# FOREST HEIGHTS ESTATES GRADING & EROSION CONTROL PLANS

FOR FOREST HEIGHTS CIRCLE  
COUNTY OF EL PASO, STATE OF COLORADO

**FOREST HEIGHTS CIRCLE  
GRADING & EROSION CONTROL PLAN**  
TITLE SHEET

Project No.: 18070  
Sheet: 1 of 4

FOREST HEIGHTS CIRCLE  
GRADING & EROSION CONTROL PLAN  
EROSION CONTROL DETAILS

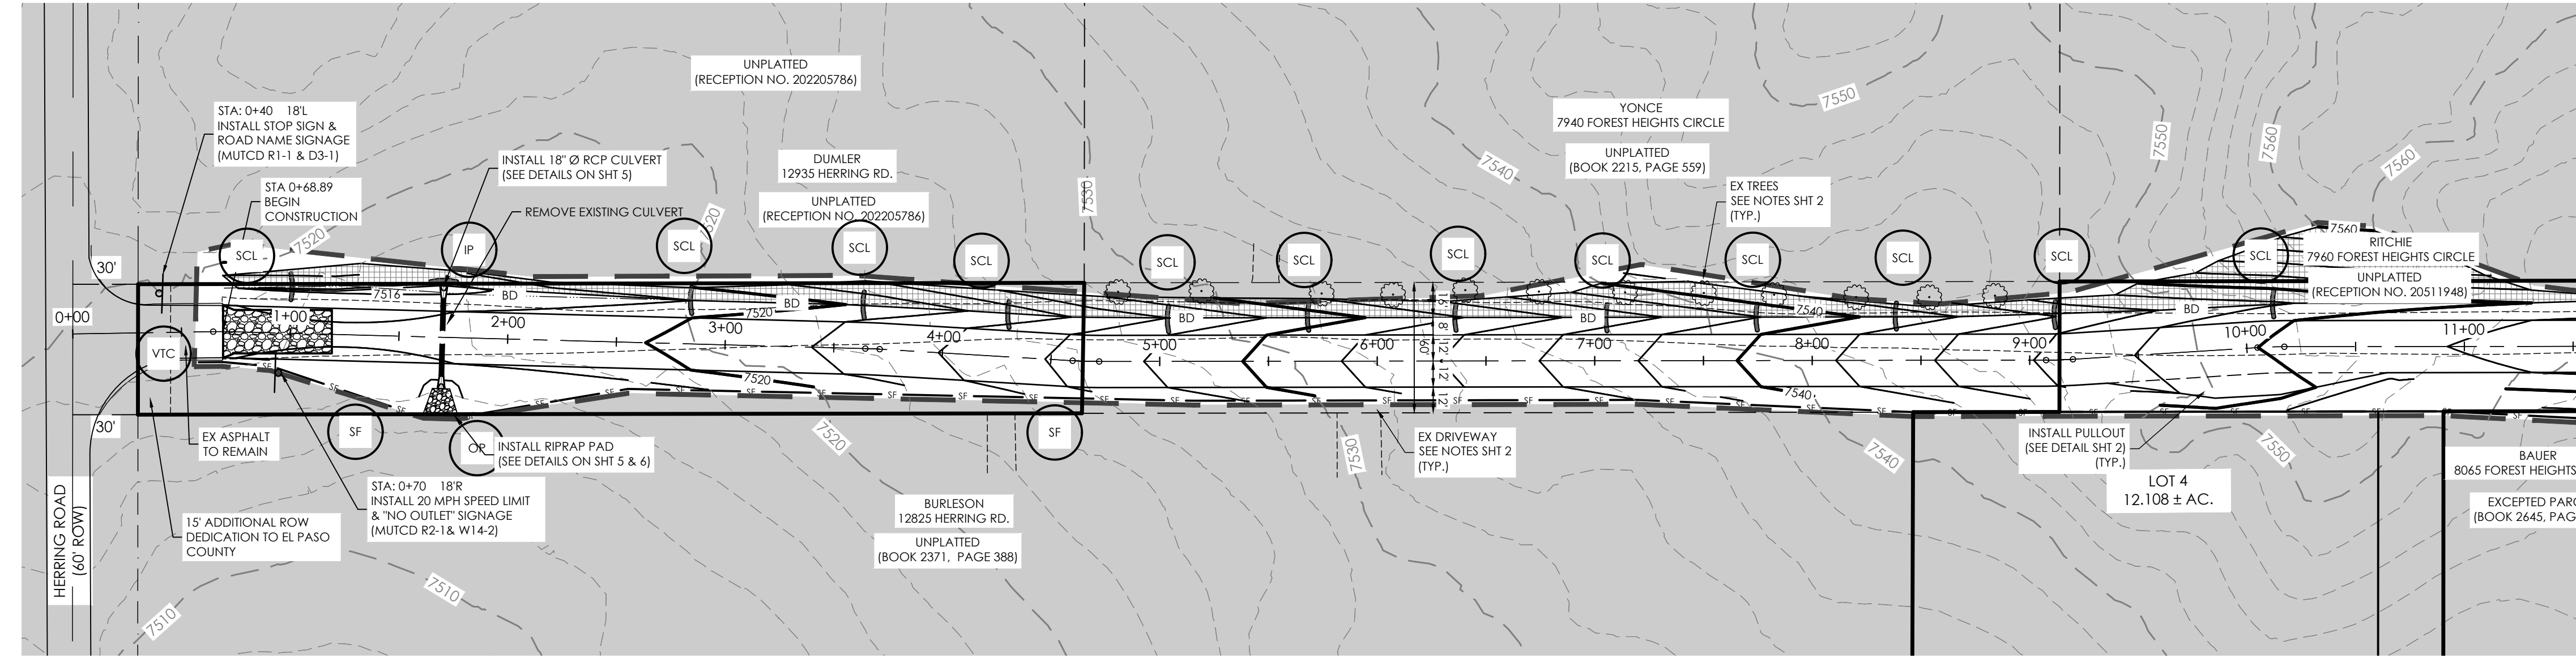
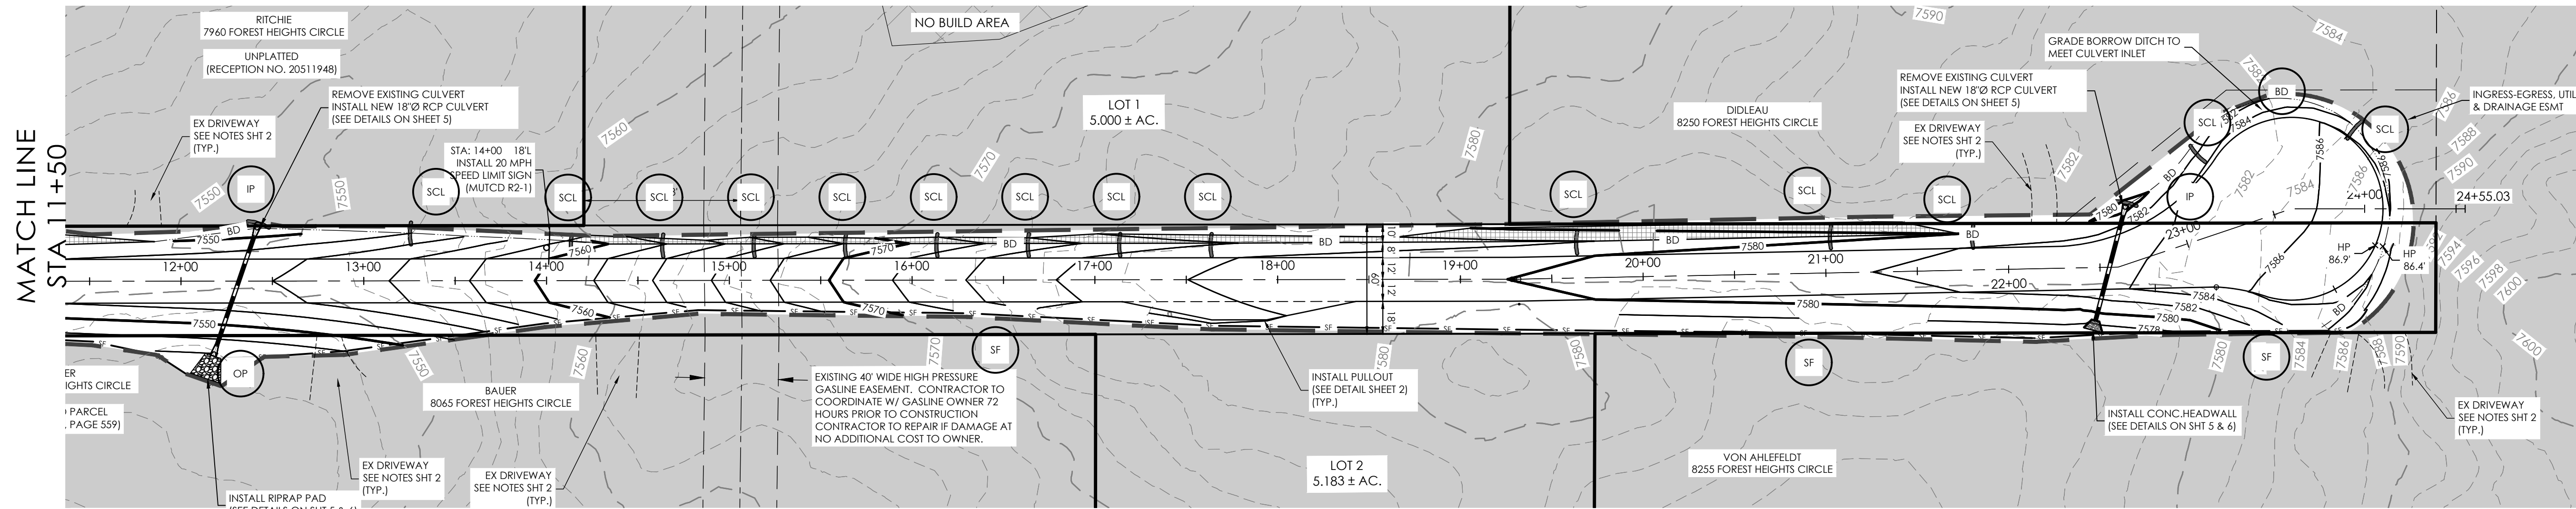
Show these approx locations of building footprints and driveways on FDR drainage map.

With this submittal, all proposed topo was "turned off" so is not visible. Please include all proposed topo on these plans with the next submittal.

Unresolved comment from Review 3:  
Show location of driveway culverts.

Unresolved comment from Review 3:  
Show approx location of wetlands as shown in the drainage map on the last page of the drainage report.

This area was not shown with the last submittal and is not shown in the FDR. Please revise to remove discrepancy.

FOREST HEIGHTS CIRCLE
GRADING & EROSION CONTROL PLAN
GENERAL NOTES AND EROSION CONTROL DETAILS

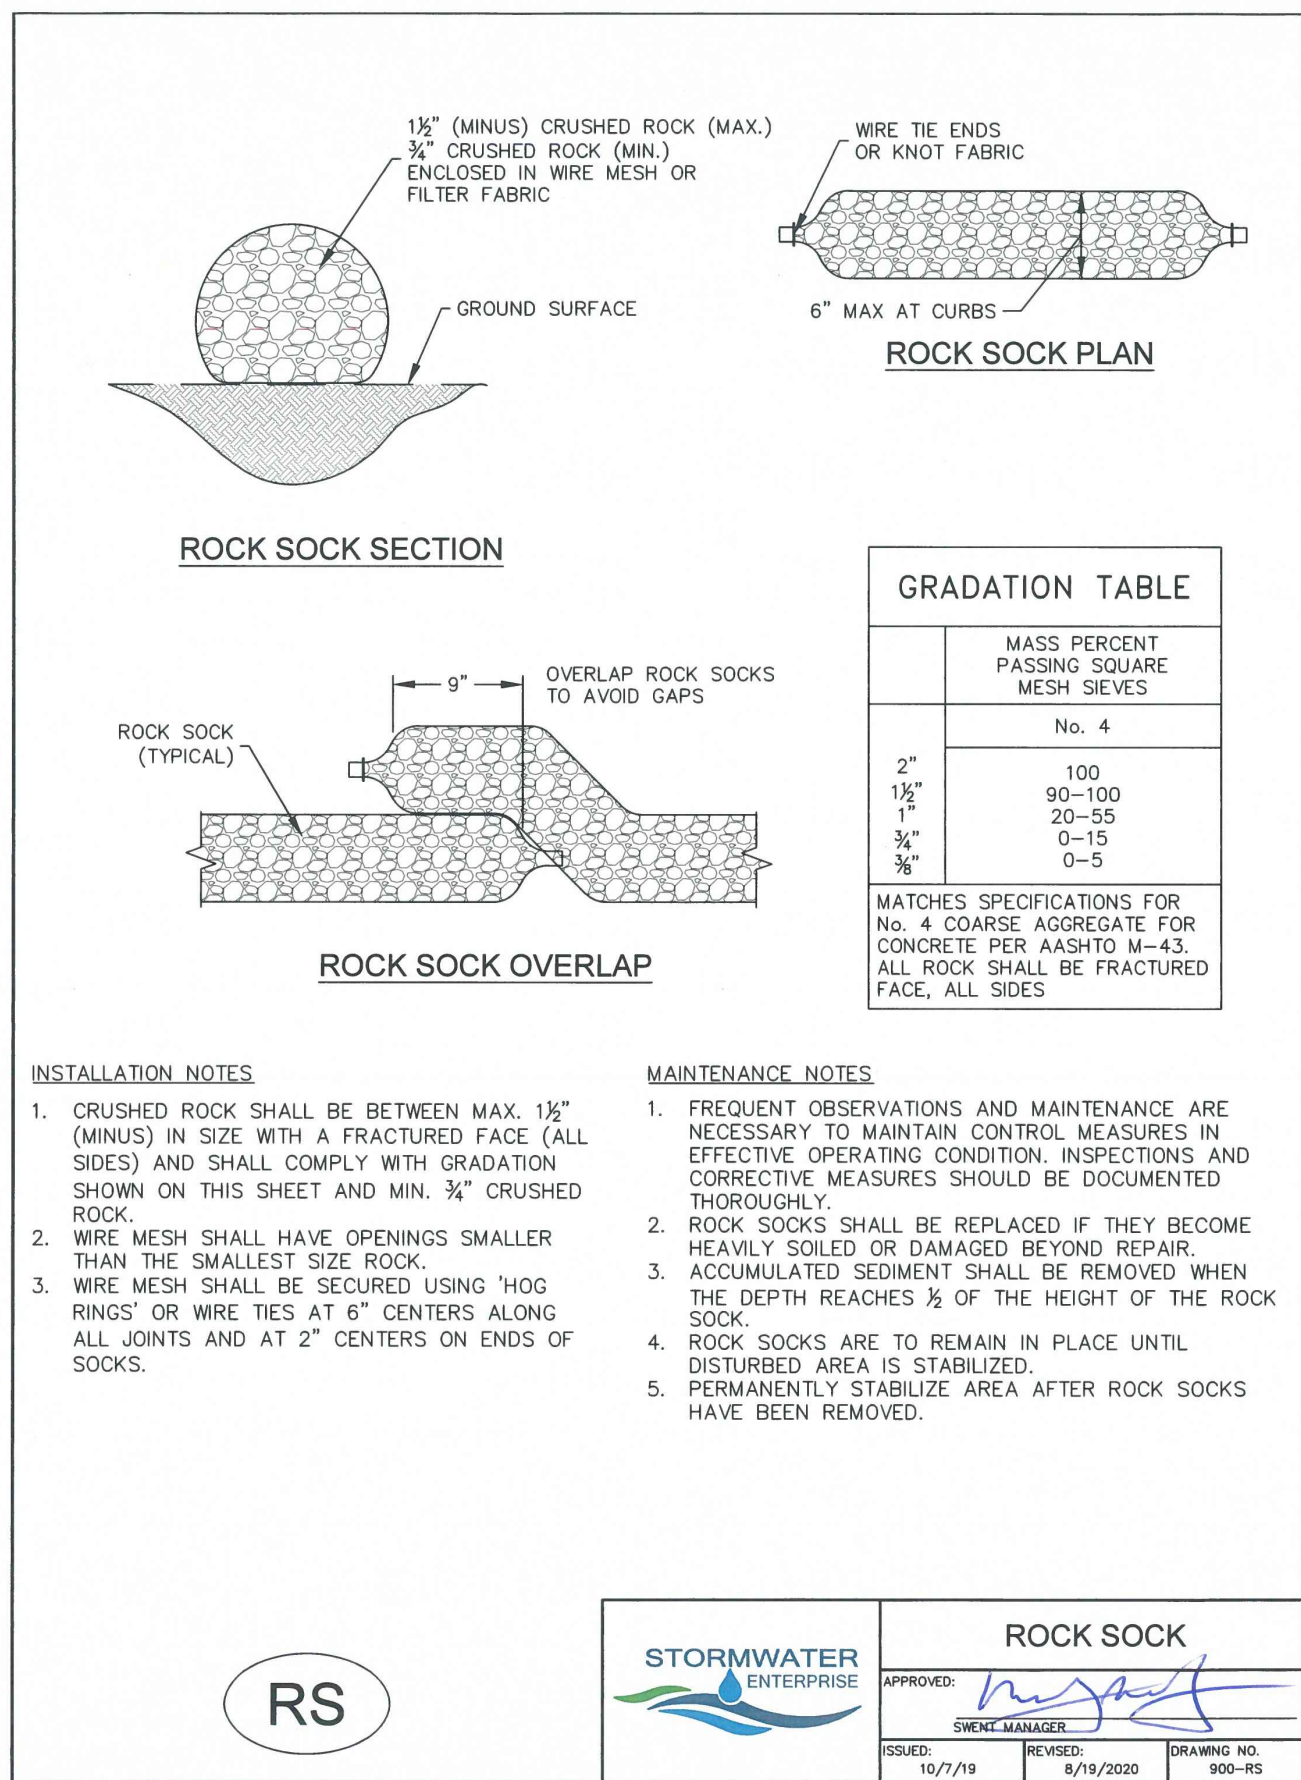
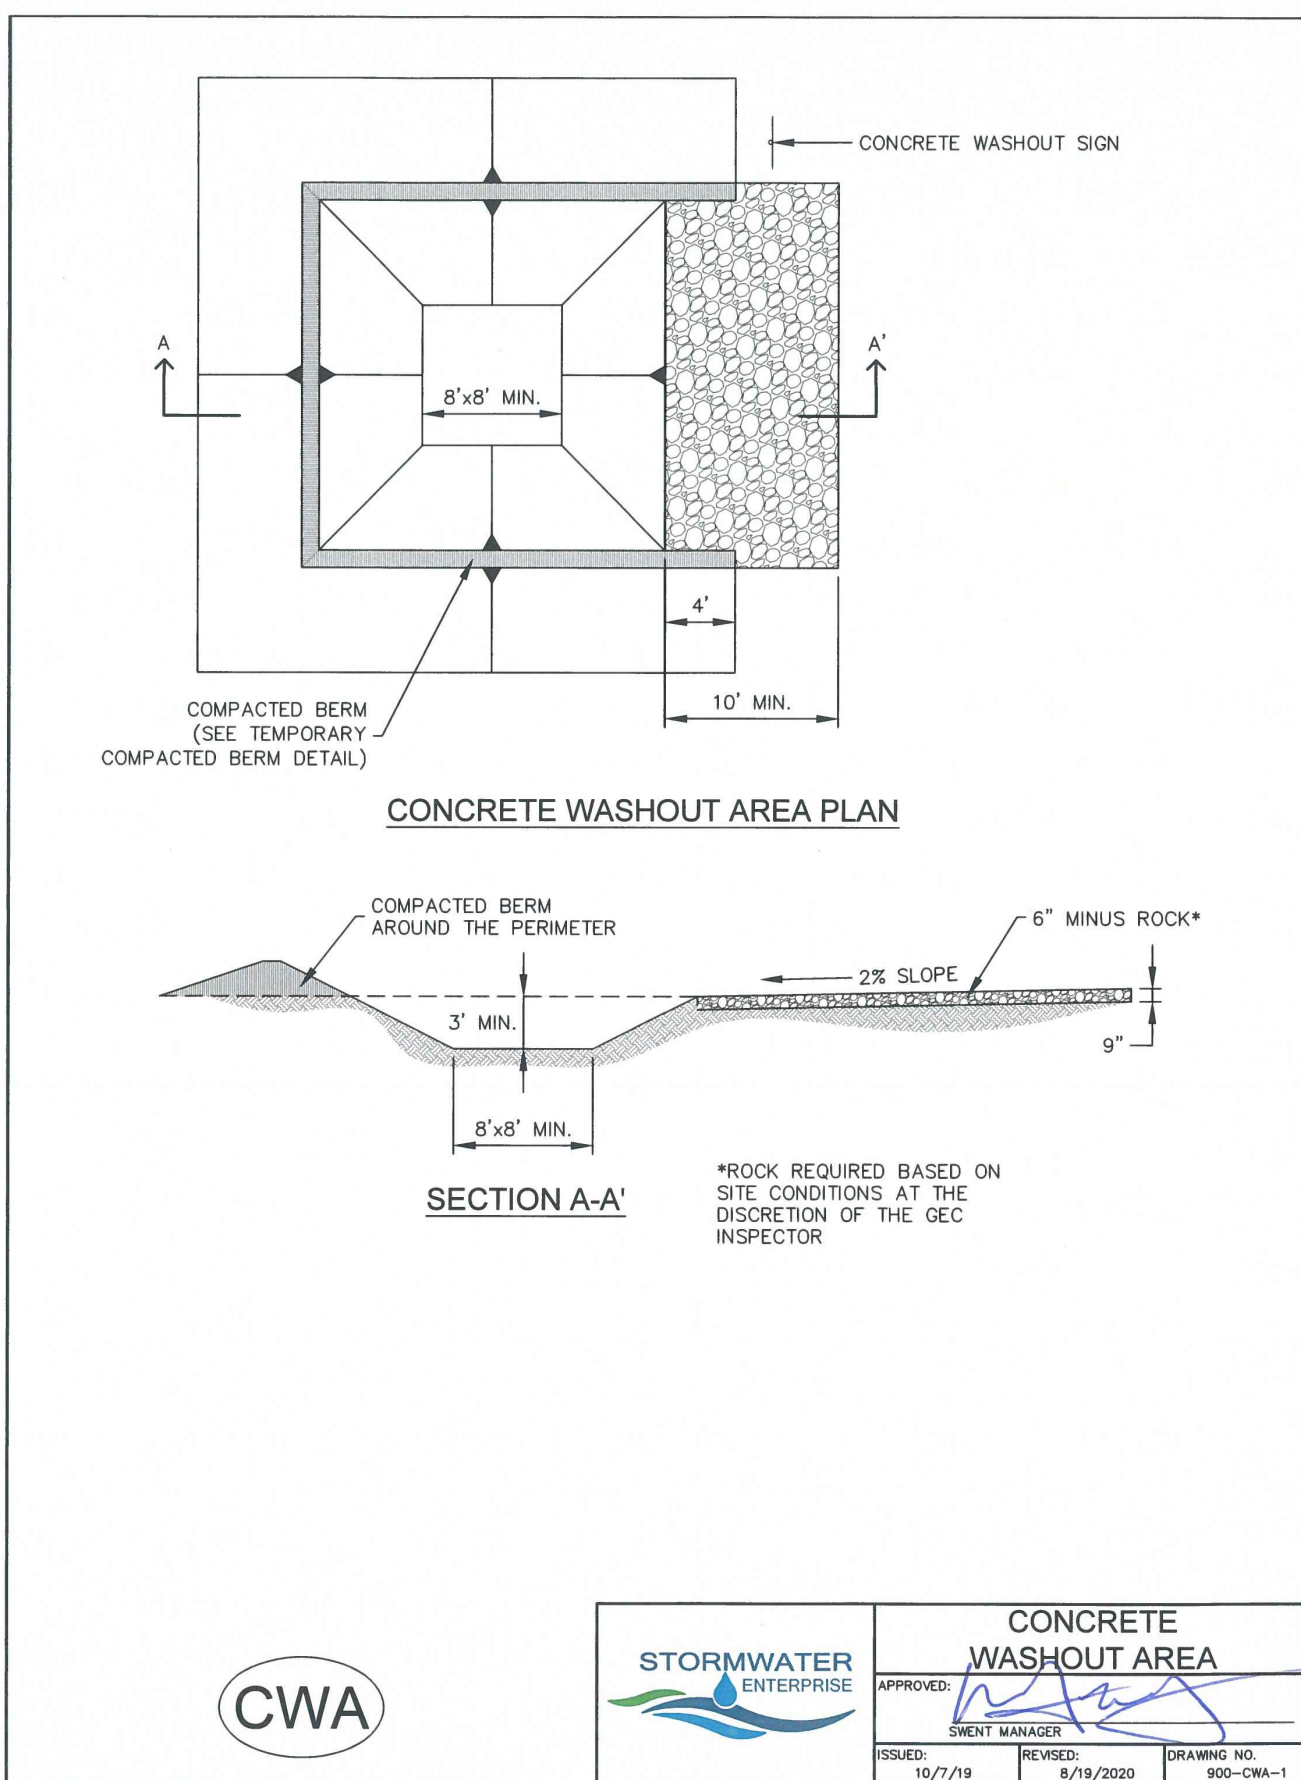
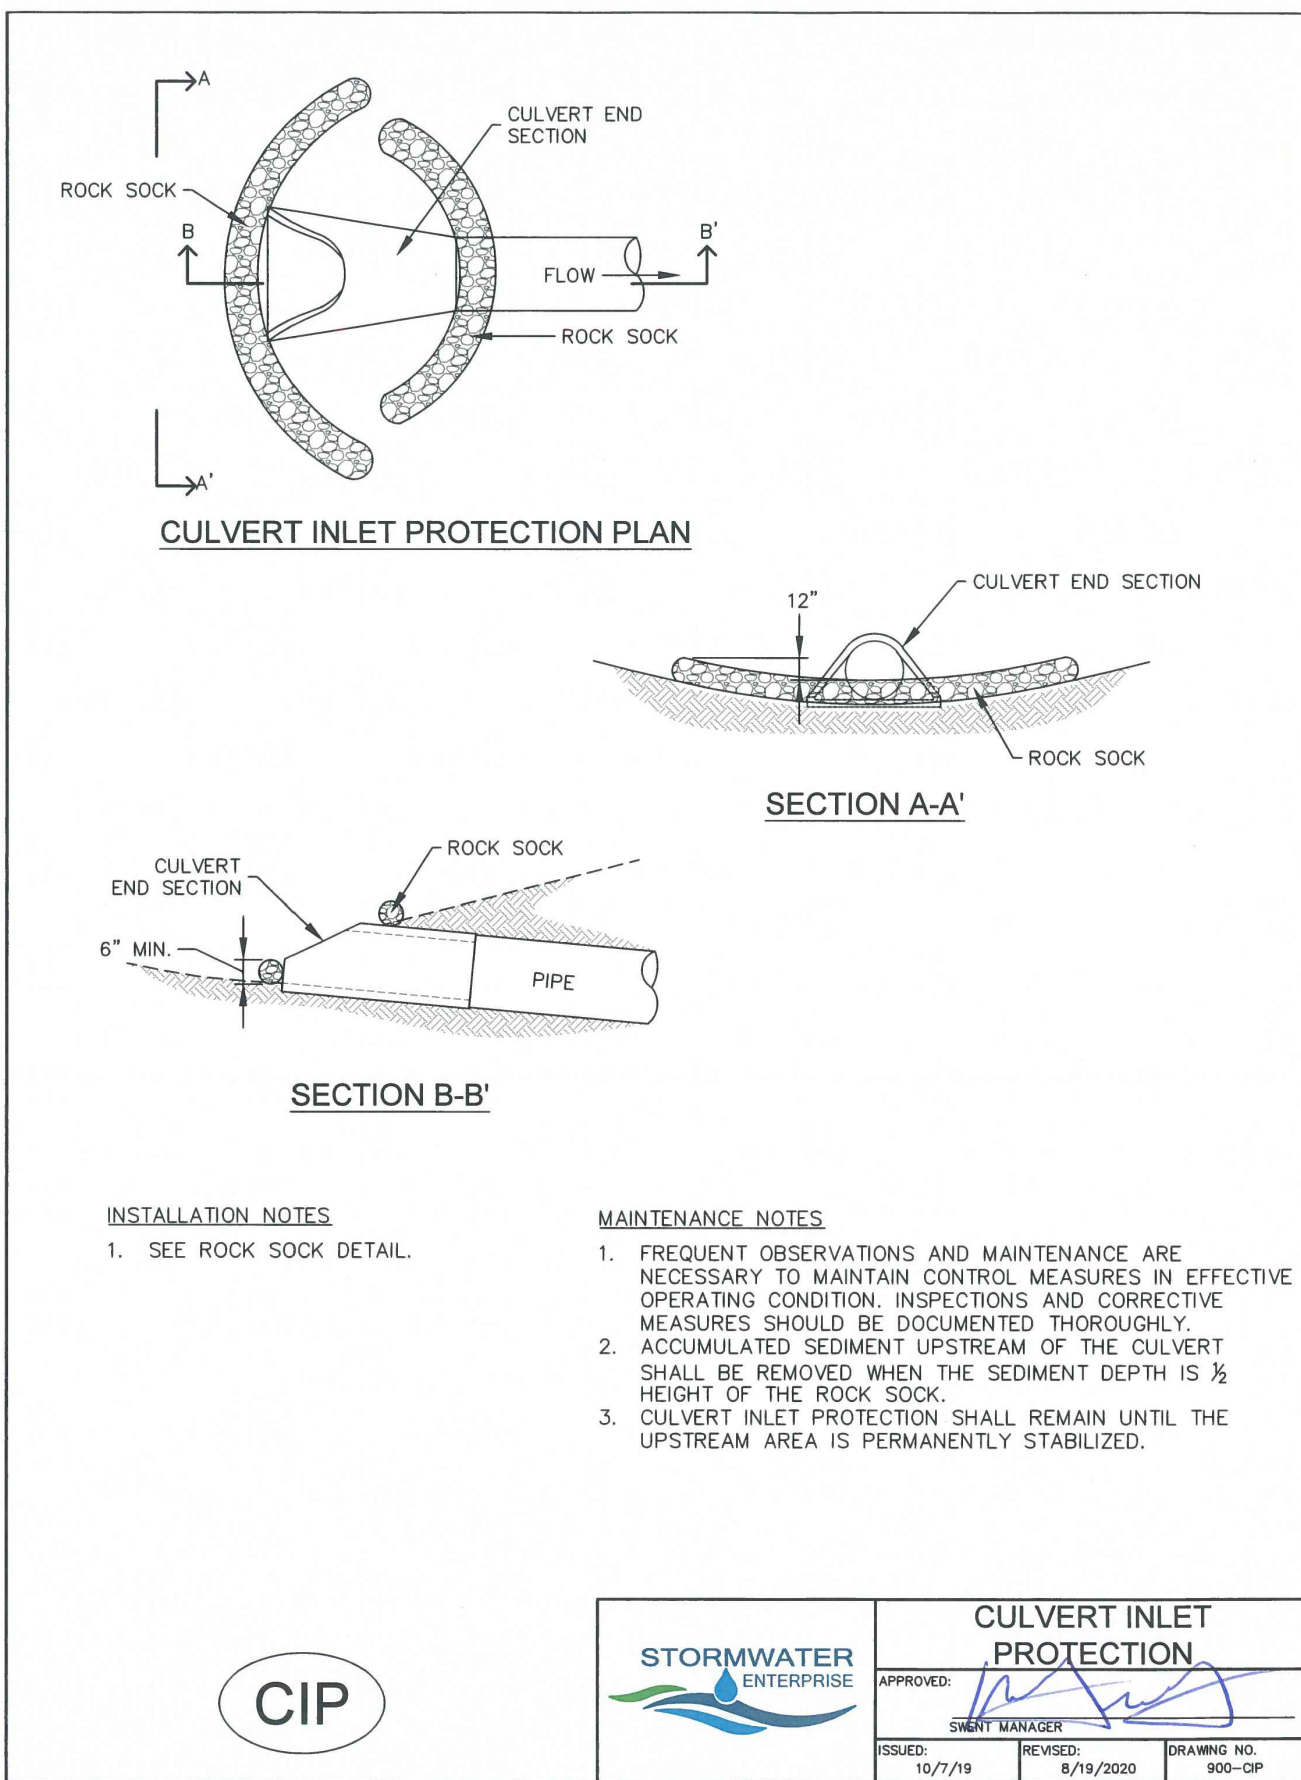
Comment generated due to changes in the document from previous submittal, per my comment on pdf pg 93 of the v3 FDR:  
It is unclear how these grass species compare to those in DCMv1 Chap 10.7, Table 10-4. Please clarify with a note here or via a discussion in the FDR what velocity and slope is permissible with these species since these are not shown on Table 10-4.

With Review #2 and #3, I asked for the VTC detail to be revised/replaced to meet our EPC criteria. With this Submittal #4, the detail was removed completely. A detail is needed since a VTC is still shown on the GEC Plan below. So please add in an acceptable VTC detail with a min 75ft length. For reference, below is my Review #3 comment:

Unresolved previous comment from Review #2:

If a VTC is added to the plans above, add a VTC detail to this sheet. And make sure to use a EPC approved VTC detail (VT-1 and VT-2 in DCMv2, Chap 3.3) or revise other detail (which usually have 50ft length) to be 75ft min length.
